Objection to Planning Application 2025/62/92206/E- 42 Robin Royd Lane, Mirfield
Wf14 0LG

Job No: 3115
 Drawing No: 004

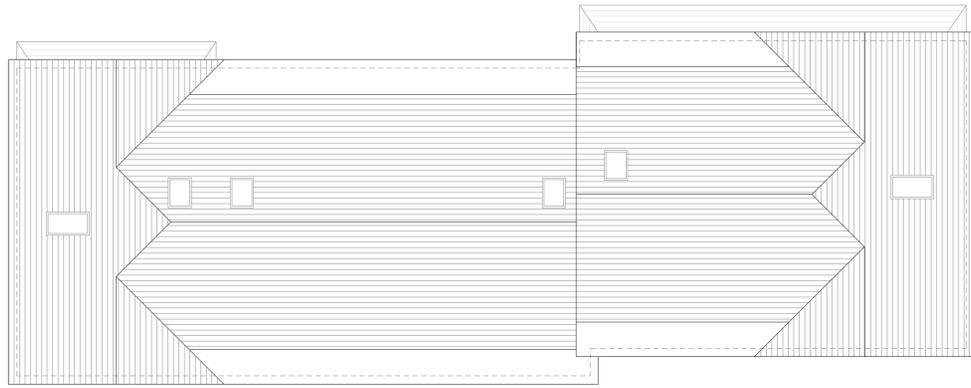
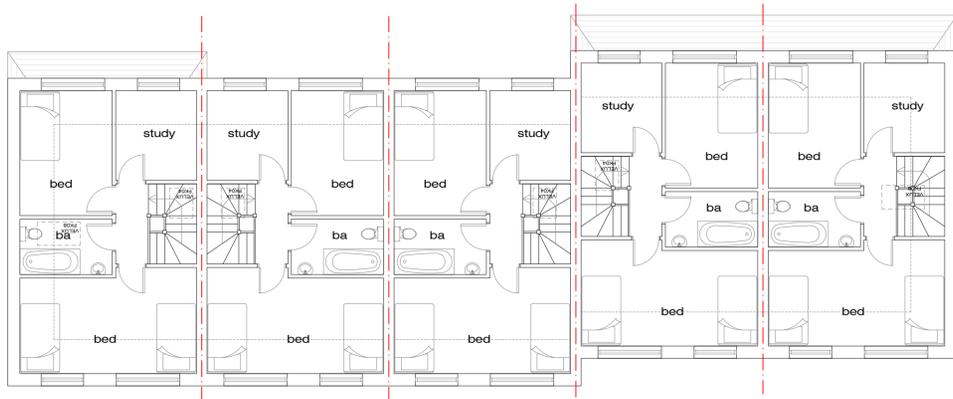
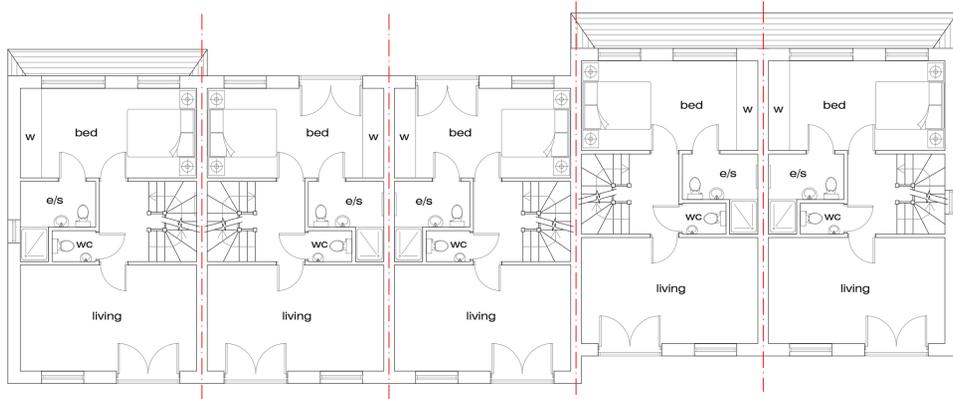
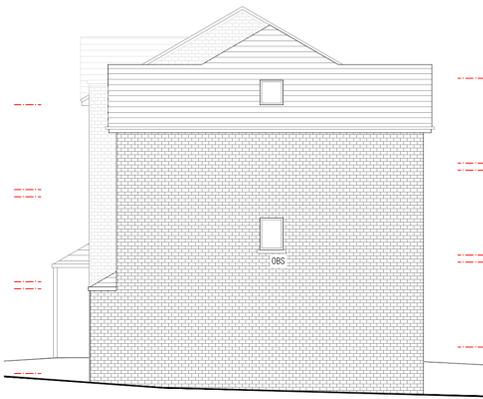
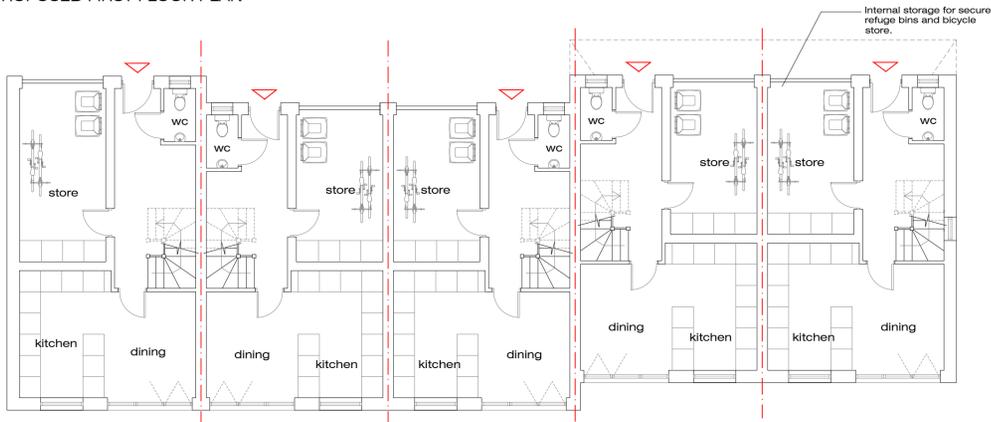
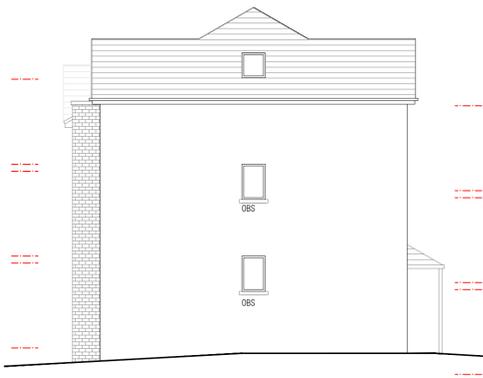
As a resident in Robin Royd Lane, being the house directly adjacent to the proposed build on the right-hand side looking from the street view. You can see our house is just over half the height of the proposed building, meaning we will be totally overshadowed and dominated by the proposed 3 story block of 5 houses, which resemble an urban apartment complex and are not in keeping with the 2-story brick and stone built houses in the vicinity. Surely this unsympathetic design, out of keeping with the local character, in terms of sheer size, height and layout must contravene LP24 (a) of the Kirklees Local Plan policy.

I am also really concerned about the potential for over population on this relatively small piece of residential land. The 5 houses are marketed as 3 bedrooms (2 of those being doubles and a single) with car parking for 2 cars in tandem on a short driveway. This means potentially 25 people, and if each house has x3 adults, potentially 15 cars, with only two tight parking spaces and a lack of suitable on street parking, meaning pavements and street corners having to be used for parking which is not only dangerous but would definitely compromise highway safety, and at least be in conflict with LP21, totally congesting the narrow lane.

Added to this, the layout of the Houses includes a study and storeroom which could easily, without permission, be turned into further bedrooms making these into 5-bedroom homes, that don't have the necessary land or infrastructure to cope with so many people, vehicles, everyday comings and goings.

I therefore ask you to please refuse this application and request an amended plan for fewer, 2 story dwellings that are more in line with the environment, therefore not negatively affecting real people's lives who actually live around that piece of land.
